Demolition of the existing garage building (B2 industrial use) and redevelopment of the site providing 9no C3 residential units - This application affects the character and appearance of River Road Conservation Area.

25 River Road Littlehampton

Thank you for your internet representation made on 12th June 2019 which has been recorded as '**an objection**' with the comments as follows:

Proposed Drawings:
Terminus Place
Roof Plan

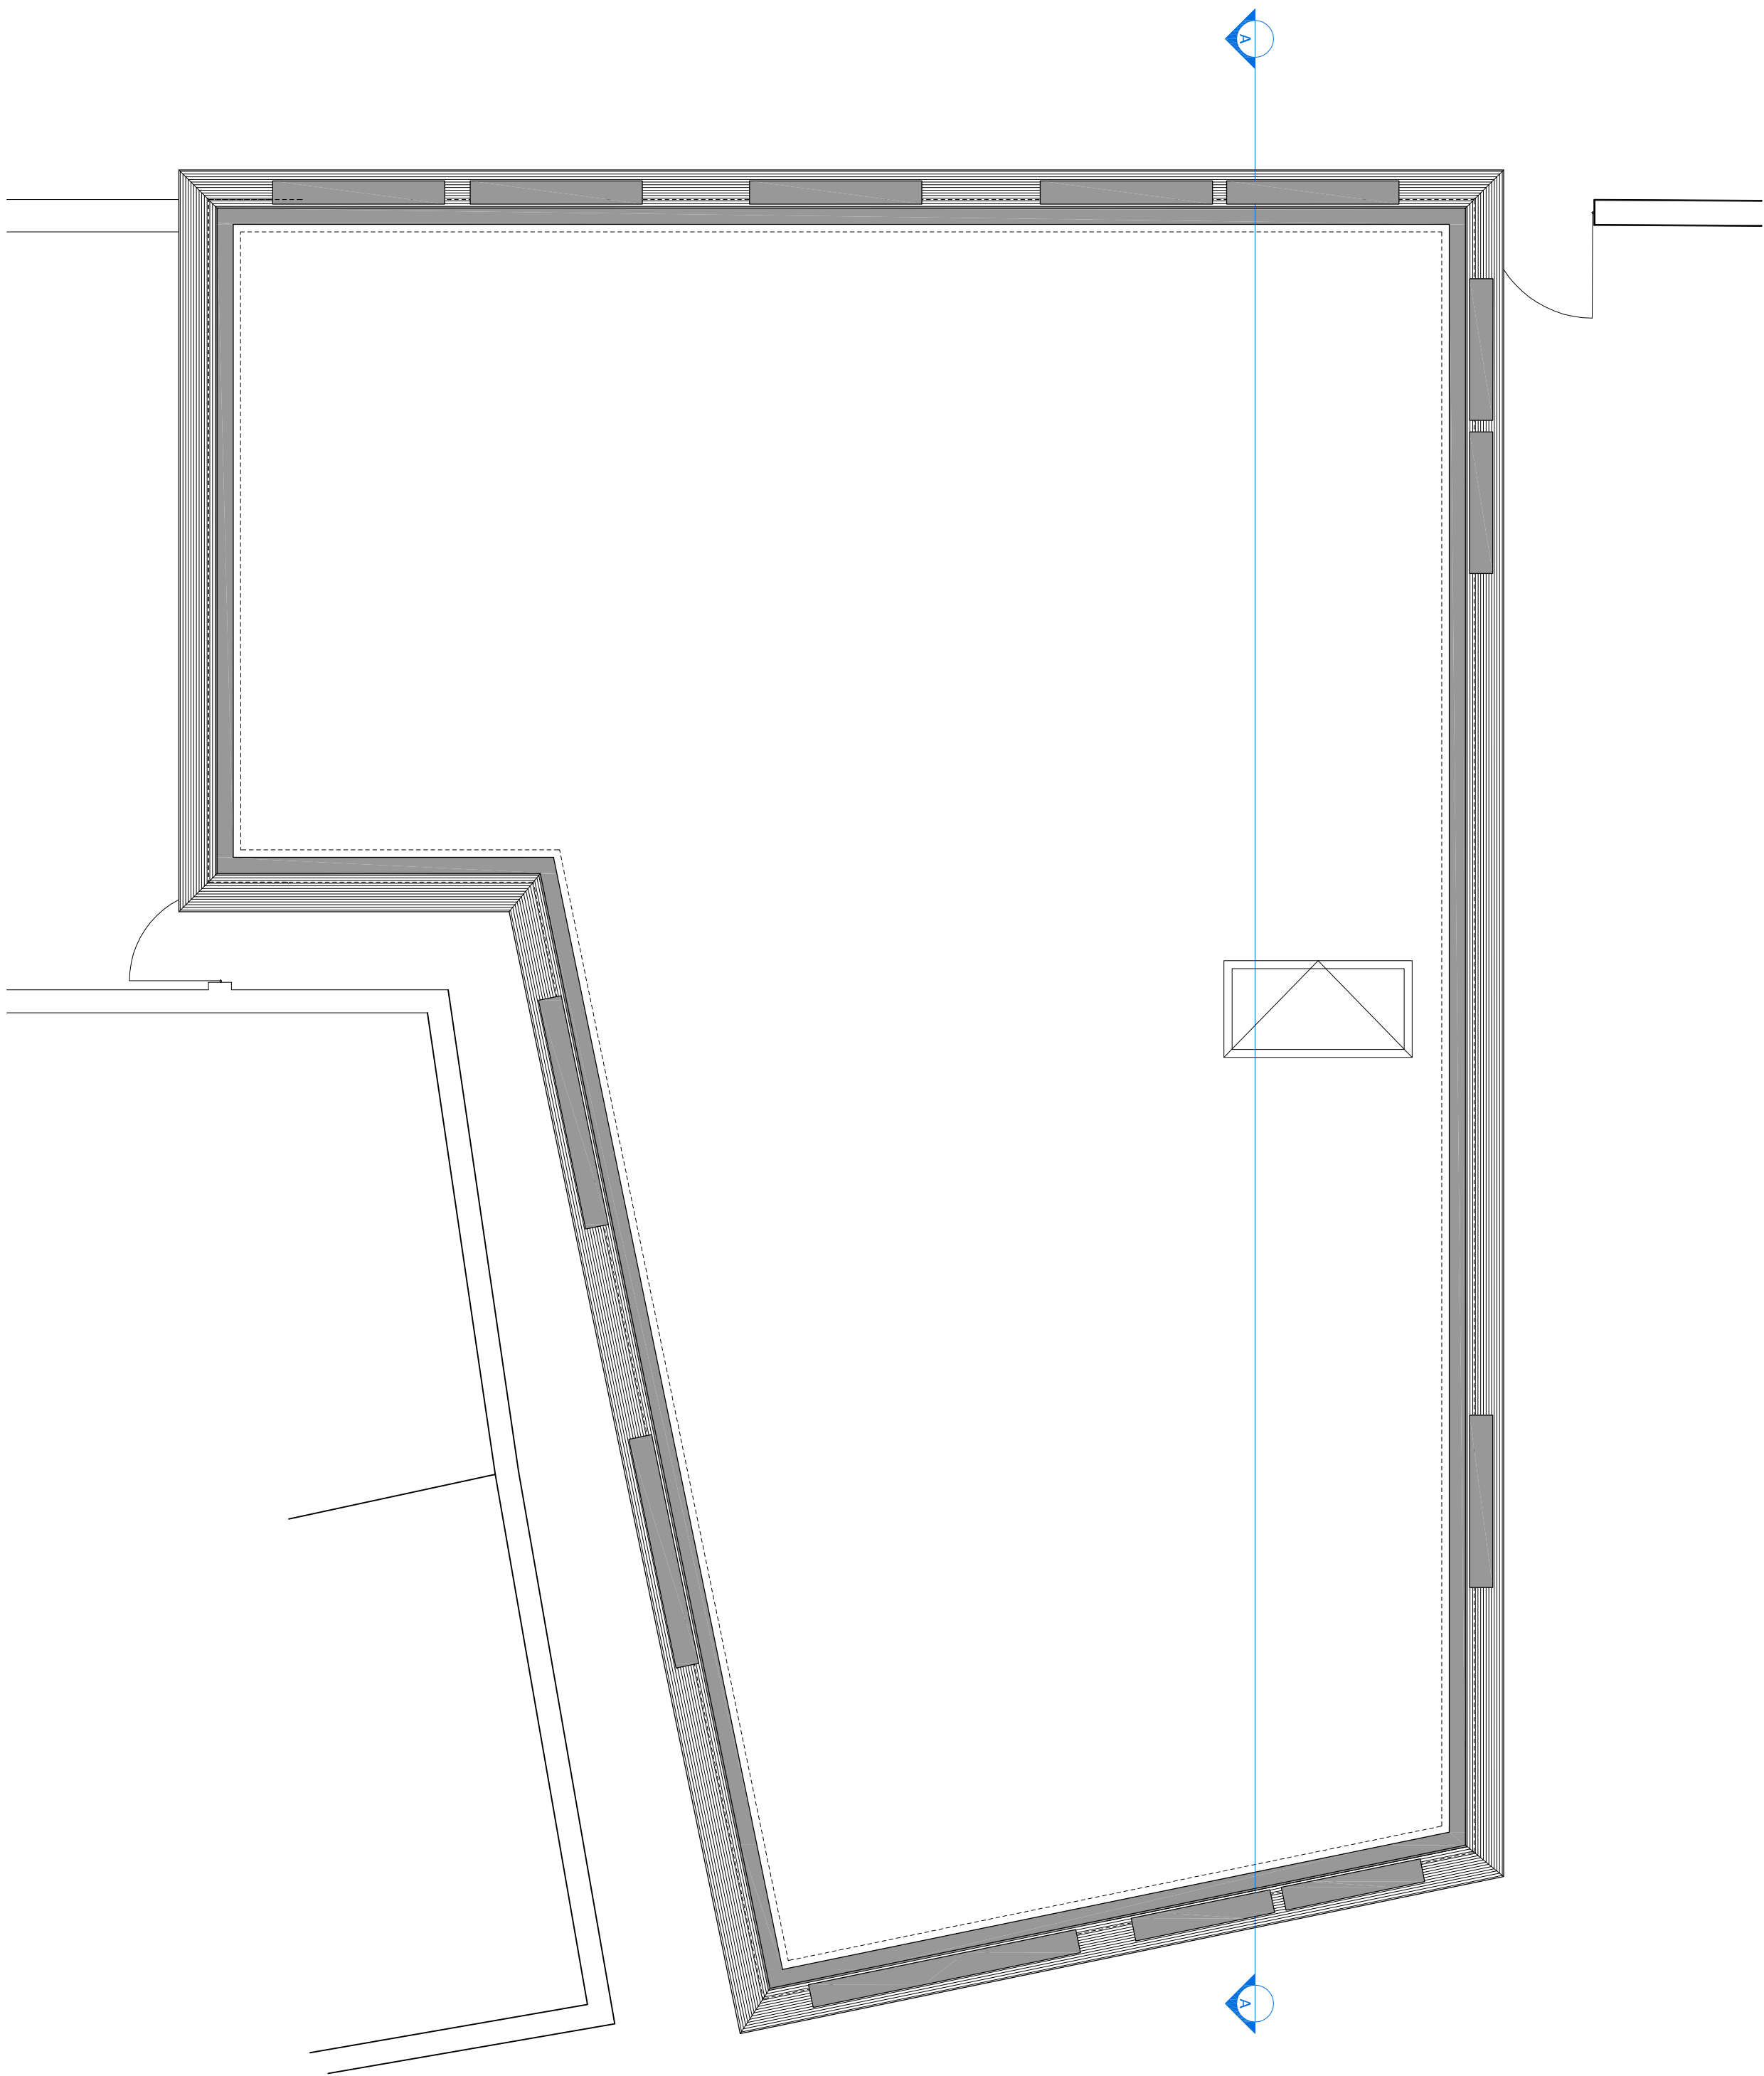
*A Mansard style roof is not appropriate in the Conservation Area where traditional pitched roof shapes predominate. A far more sensitive approach is required. The development should*

PROPOSED DRAWINGS:
Terminus Place
Proposed & Existing Street Scenes

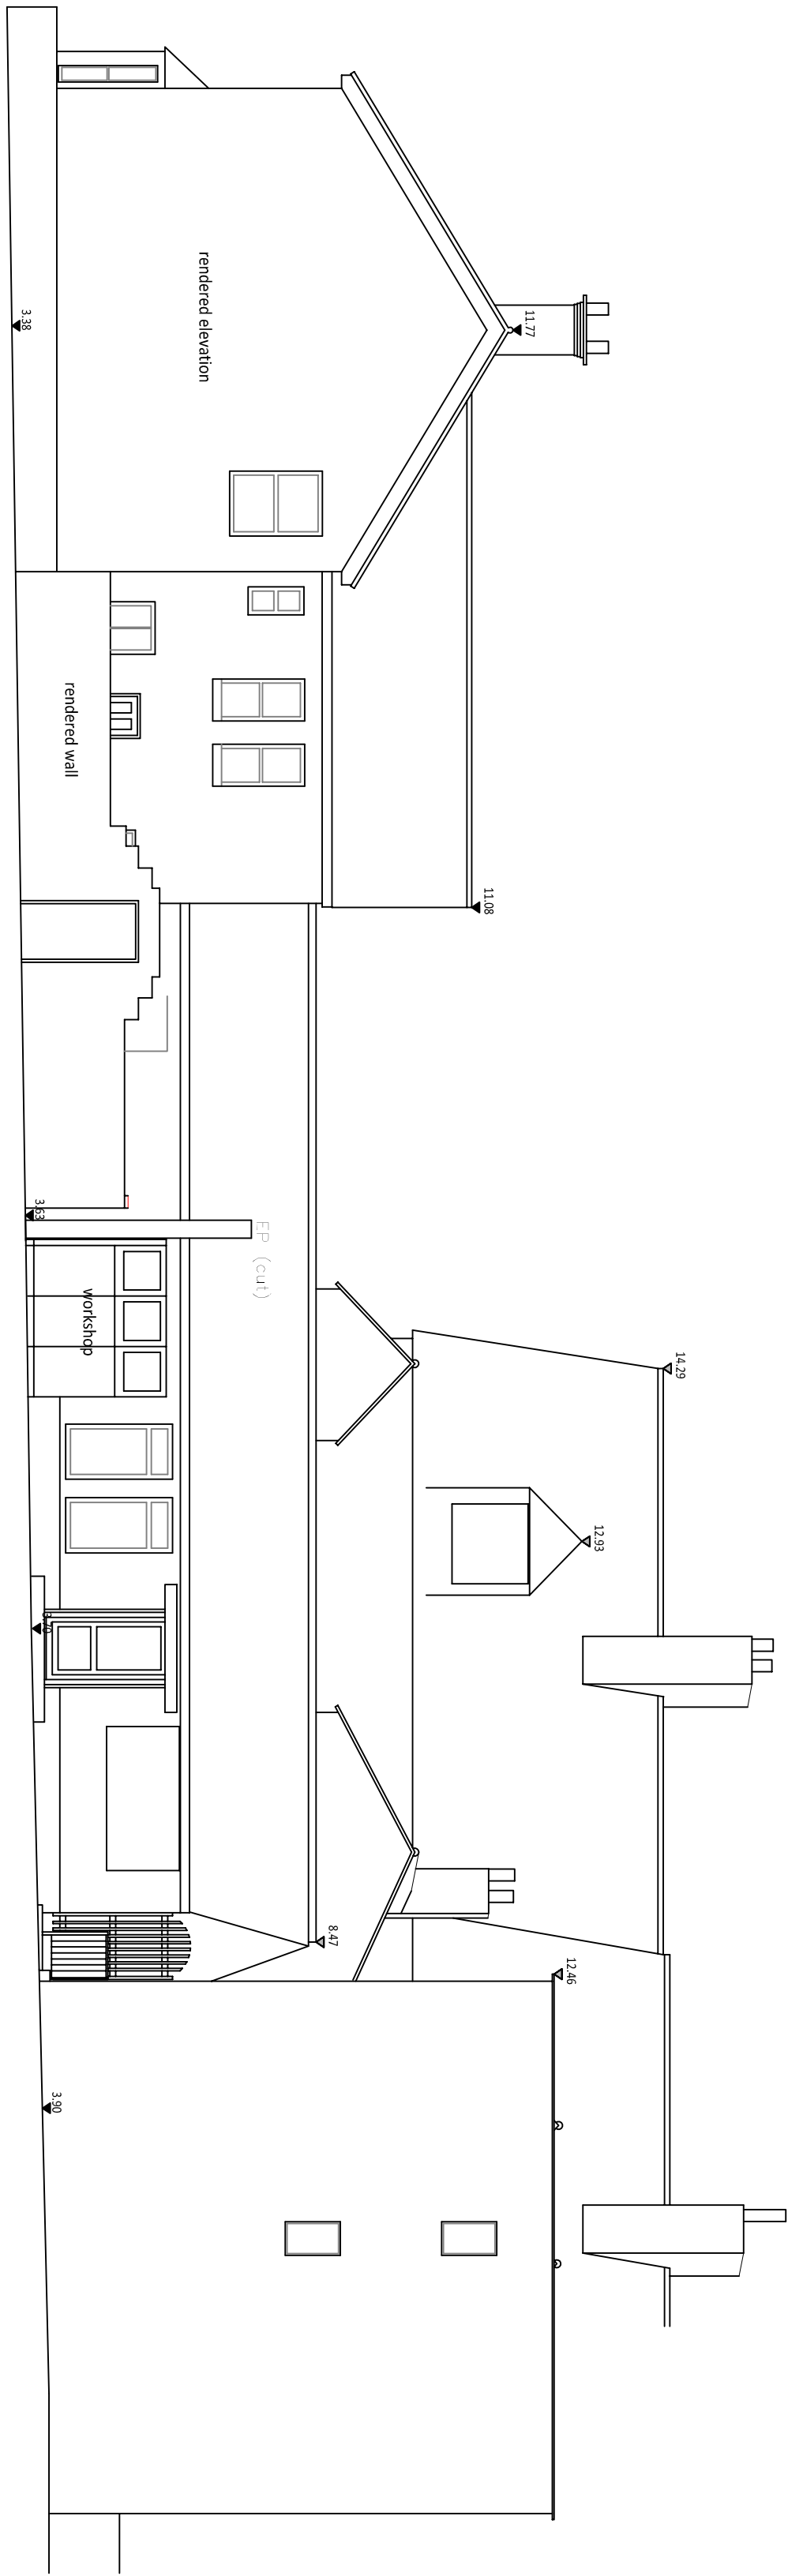
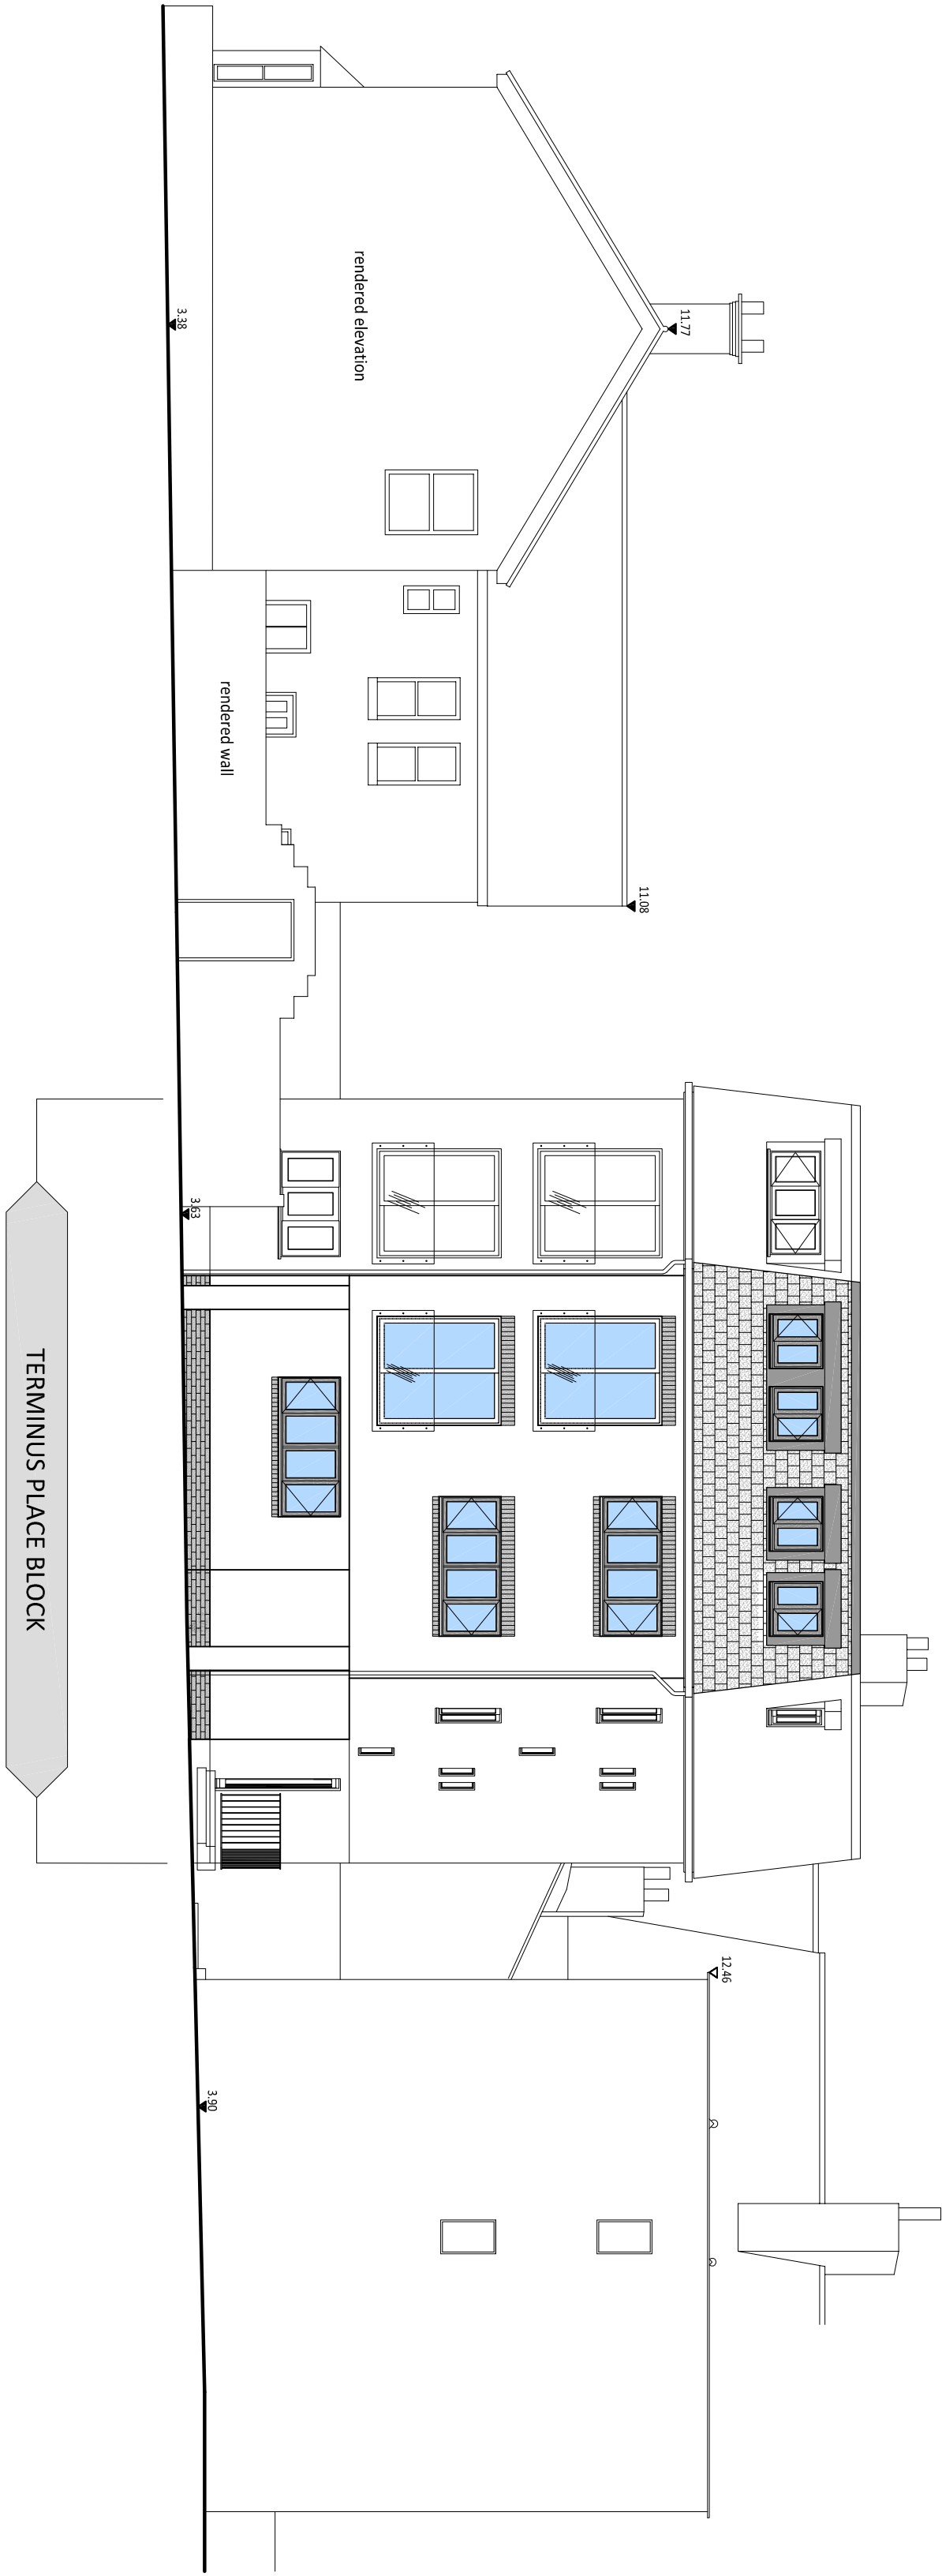
*The proposed development is in the River Road Conservation Area and will have a harmful effect on it. The scheme is overlarge, too high, too dense and far below the quality of form and external design needed for this site.*

*complement and enhance the adjoining Terminus Place where the east side of the street has a particular character with its*

*small scale two storey buildings with traditional windows, doors and roofing materials.*
